Project #: 1009886

Application #: 13DRB-70745

Project Name: MRGCD MAP # 40

****Your request was approved on 11-21-13 by the DRB with delegation of signature(s) to the following departments - outstanding comments to be addressed****

**PLAT OF
LOTS 1 & 2
LANDS OF ABENICIO GALLEGOS**
BEING A REPLAT OF TRACT 68, 82-A-2, 82-A-1-A & 82-A-1-B
M.R.G.C.D. MAP NO. 40
PROJECTED SECTION 20, T 10 N, R 3 E, NMPM, TOWN OF ALBUQUERQUE GRANT
CITY OF ALBUQUERQUE, BERNALILLO COUNTY, NEW MEXICO
NOVEMBER, 2013

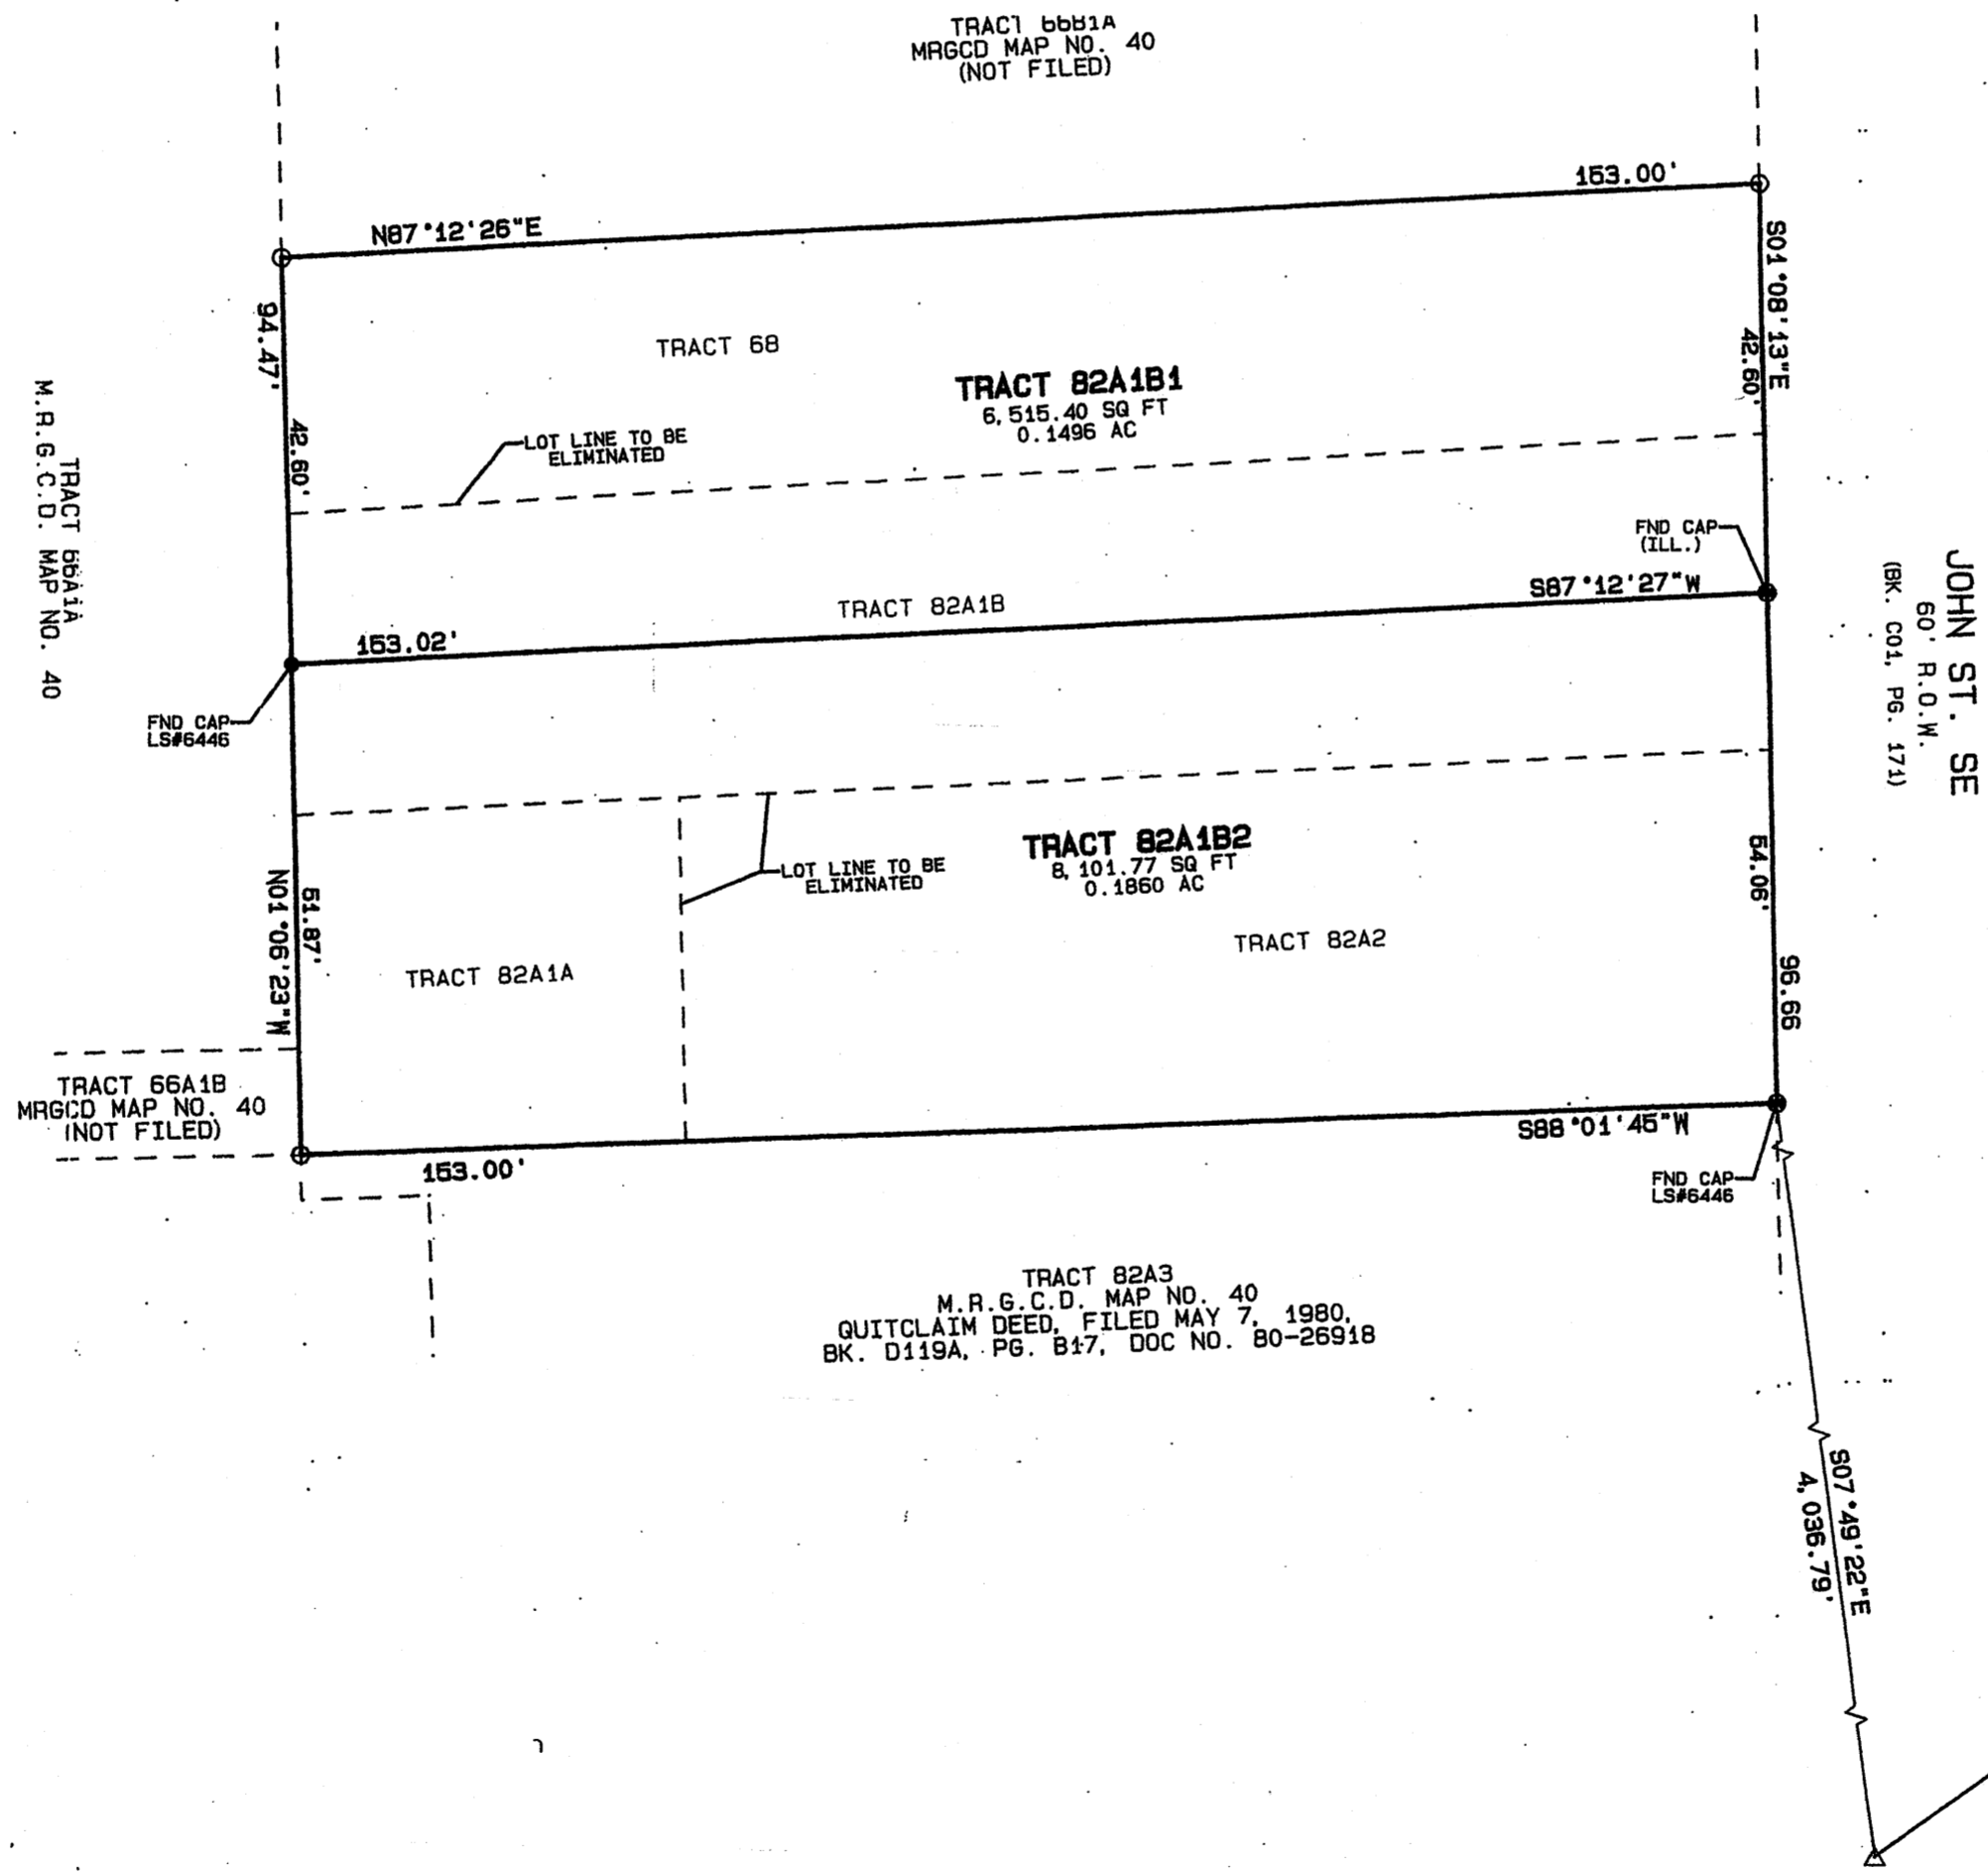
PLANNING (Last to sign): • revise Note 11 to 8-16-12

• delete Note 12
• utility signatures
